Application No: LU/269/15/HH

Recommendation Report for Planning Permission for Works or Extension to a Dwelling

LOCATION: 95 Griffin Crescent
Littlehampton

PROPOSAL: 2 storey side extension & dormer in rear roof slope. This application may be determined by Littlehampton Town Council under delegated powers

PROPOSED REAR ELEVATION

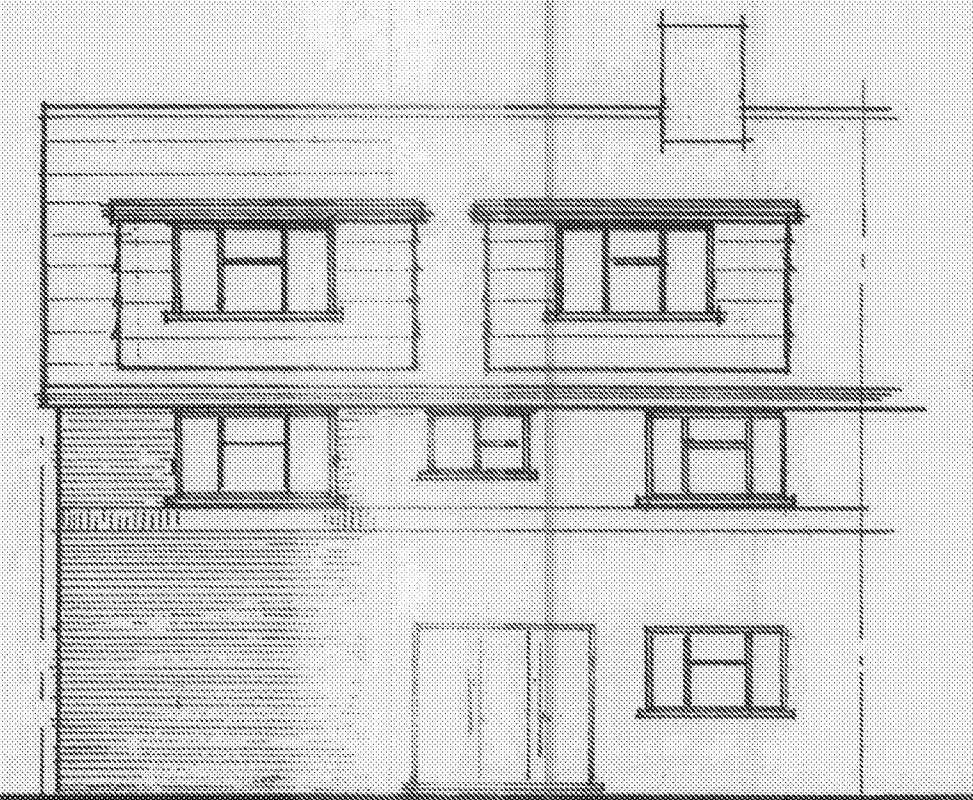
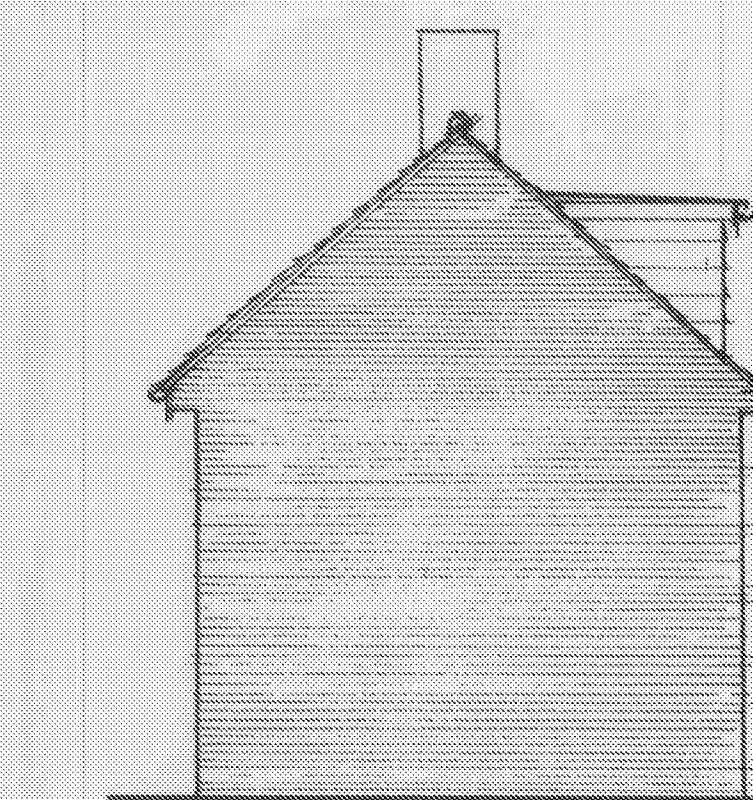
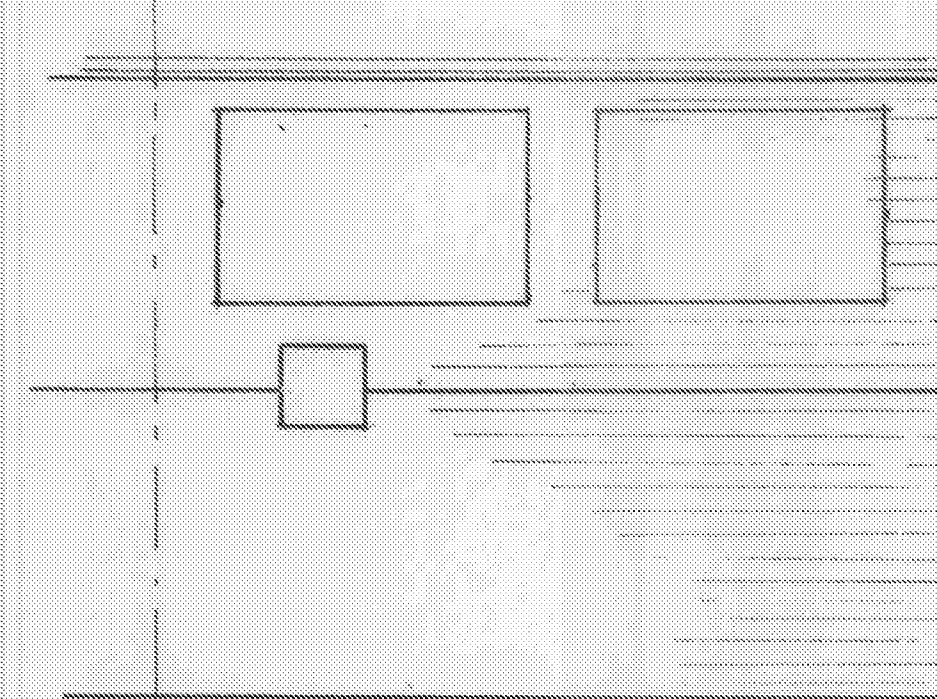
Officers Comment: The proposed scheme has been amended with the gable end having been altered and replaced by a hipped roof which will match in design and appearance that already present at the dwelling. Therefore, the proposal is now considered to comply with relevant local development policies.

The proposal has been amended with the proposed gable end being omitted and the proposal now featuring a hipped roof in accordance with the established character of the area.

The proposed two storey side extension therefore considered to appear subservient and well integrated with the existing dwelling and as such is deemed to be in accordance with policies GEN7 (ii) and DEV19 (i), (ii) & (v) of the Arun District Local Plan.

The application seeks permission for the construction of a two storey side extension and the addition of two rear dormers on the rear elevation of the dwelling. The proposed two storey side extension will extend 3 metres to the side of the original dwelling with the eaves and ridge height matching that of the original dwelling.

PROPOSED 2nd FLOOR PLAN

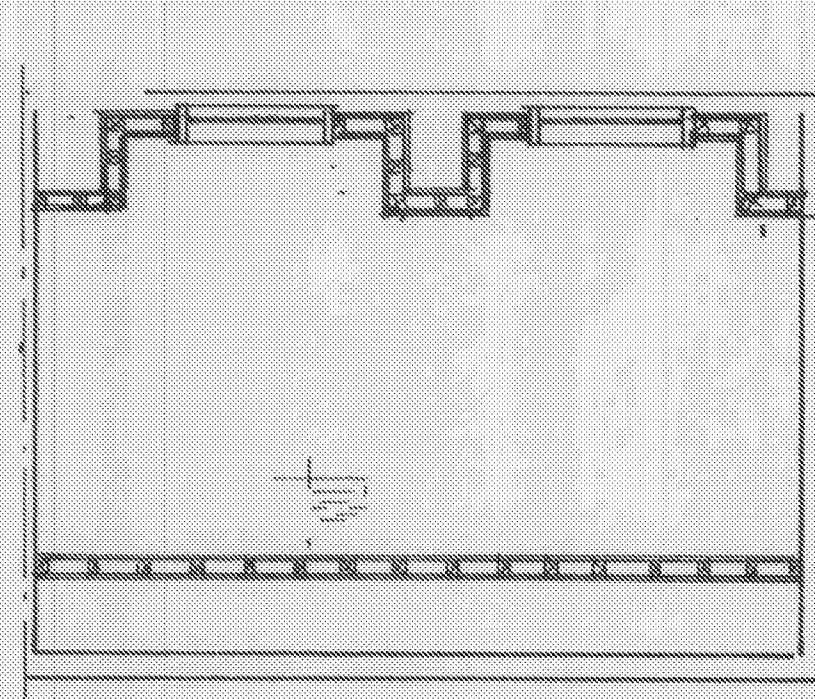
The proposed dormer on the rear elevation of the property is considered to be acceptable and due to its position and scale will appear subservient and well integrated with the host dwelling in accordance with policies GEN7 (ii) and DEV19 (i) & (ii) of the Arun District Local Plan.

The proposed rear dormer by virtue of its design and location is not considered to give rise to any overbearing or overshadowing impacts. The dormer is located 25m from the rear boundary of the site and as such will not give rise to any unacceptable overlooking of adjoining residential properties. Therefore, the proposed dormers are considered to be in accordance with GEN7 (iv) and DEV19 (iii) of the Arun District Local Plan.
